From: Lewis, Trevor [Trevor.Lewis@lancashire.gov.uk]
Sent: 04 February 2013 15:42
To: Graeme Thorpe
Subject: 3/2012/1110 Quarry House, Tosside - highways comment

Please note the following highways comments.

Drawing Title
Proposed Plans, Site Plans and Sections

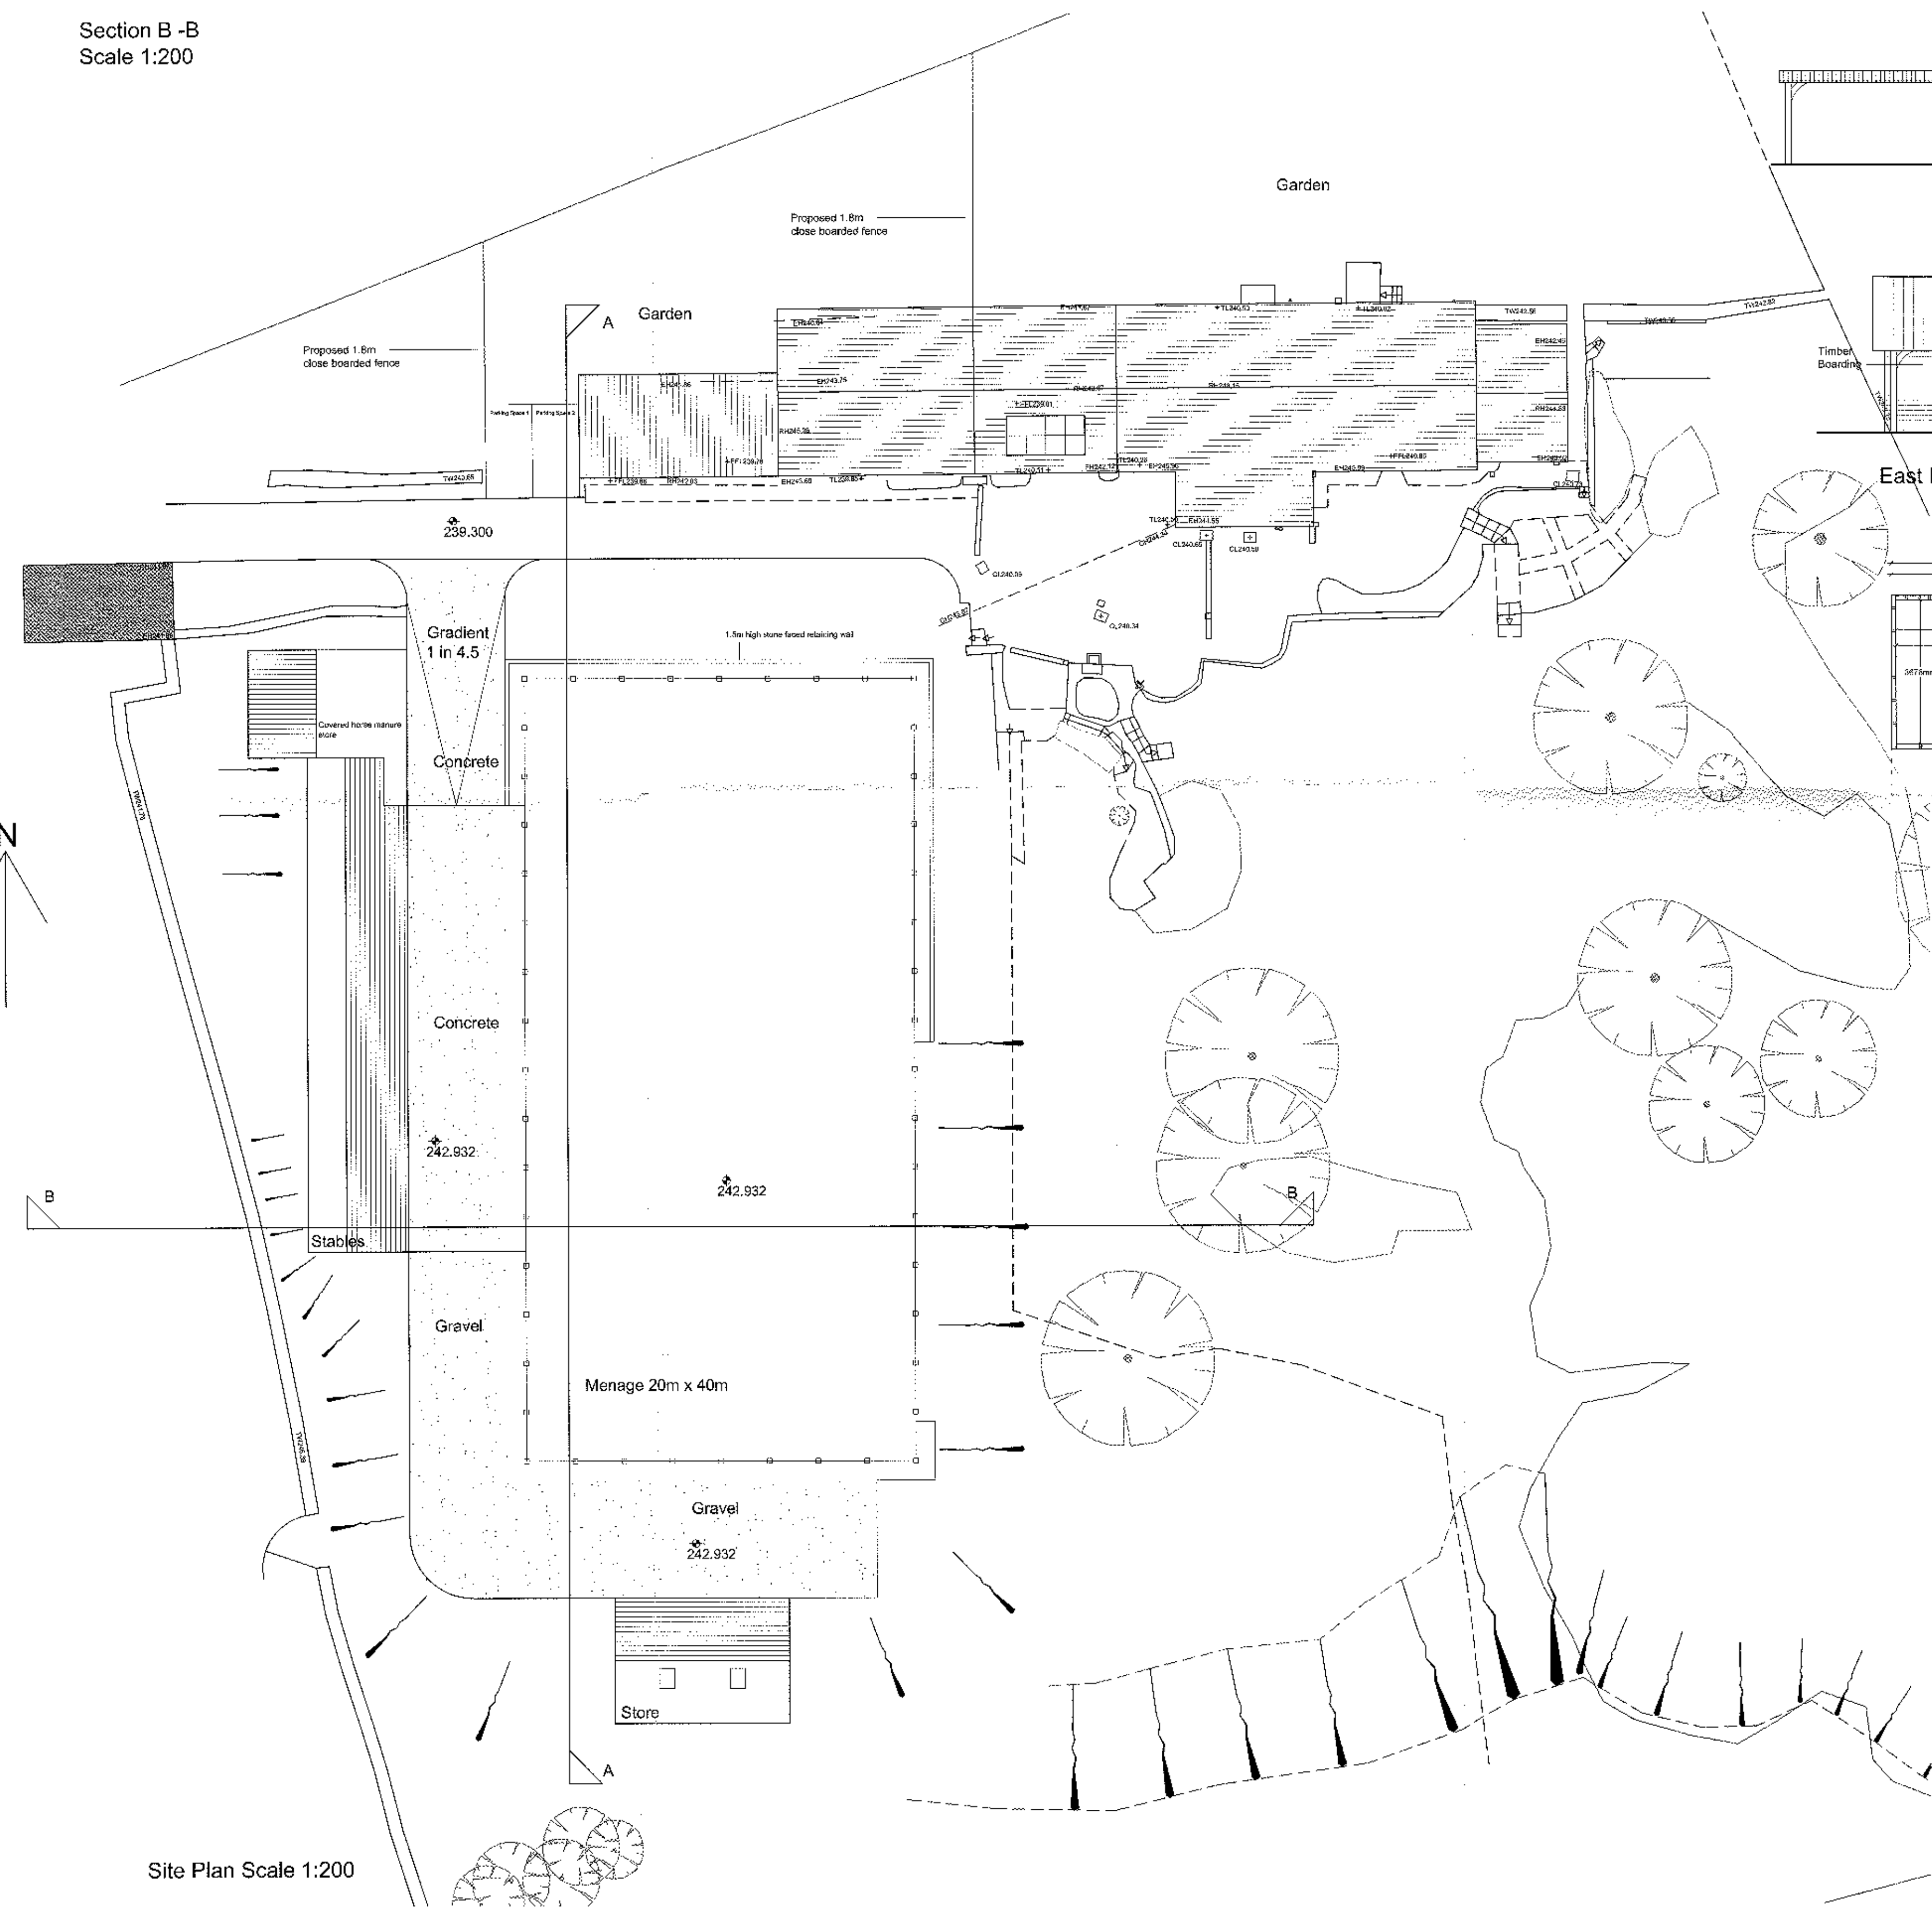
The access onto Dugdale Lane should be increased in width to a minimum of 4.5m for a distance of 6m measured from the edge of the carriageway. This is to ensure that two vehicles can pass driving in and out of the access. The gate should be re-hung to open away from the highway.
